**Emailed January 7, 2021**  
DRB Comments for Meeting on 1/13/2021

**From:** Nicole M. Friedt, P.E., Development Review Engineer  
AMAFCA

**RE: DRB COMMENTS for PR-2020-004604**

**LOTS 17, 18, 19, AND 20 BLK 9, NORTH ALBUQUERQUE ACRES TRACT 3, UNIT 3, and PARCEL 4 of DESERT RIDGE PLACE UNIT 1: ZAP: C-20**

**A1.10**  
PRELIMINARY SITE PLAN

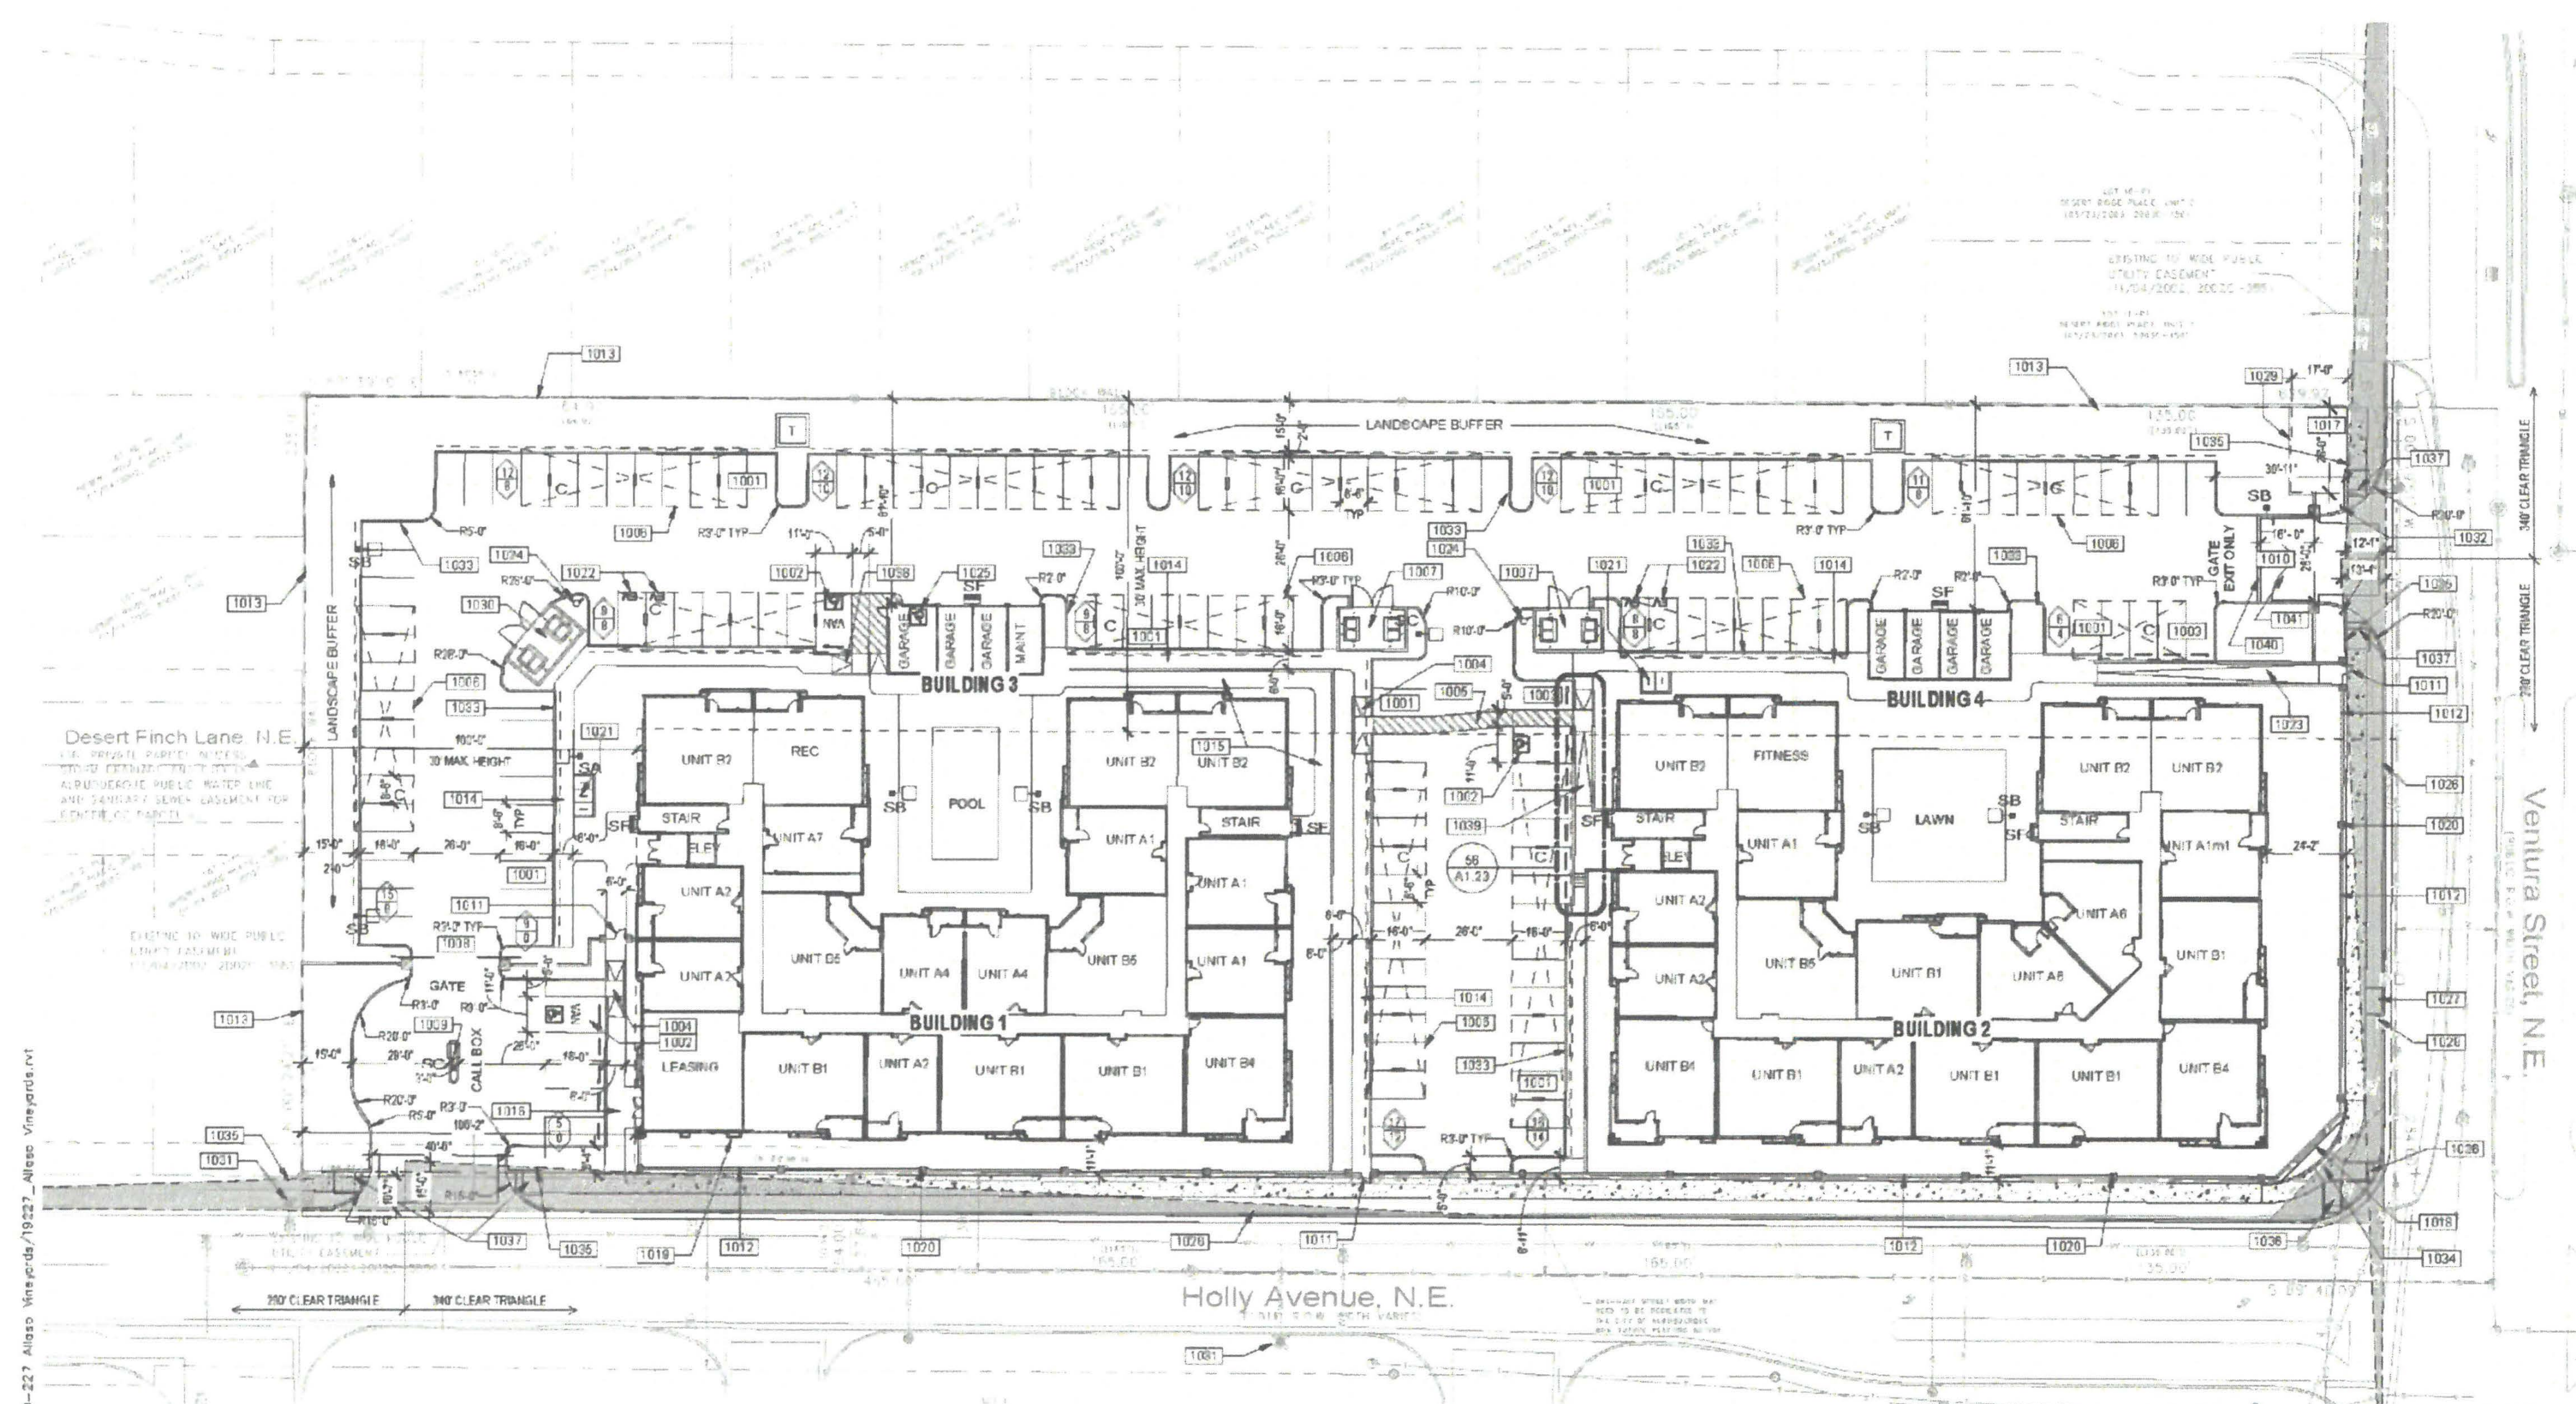
SI-2020-01467 Site Plan

- This site falls within the North Albuquerque Acres Drainage Master Plan and thus has limitations to the increase in storm water runoff associated with the development of this property.
- AMAFCA has not received the Grading and Drainage information associated with this Site Plan to verify the Site Plan is consistent with the NAA DMP.
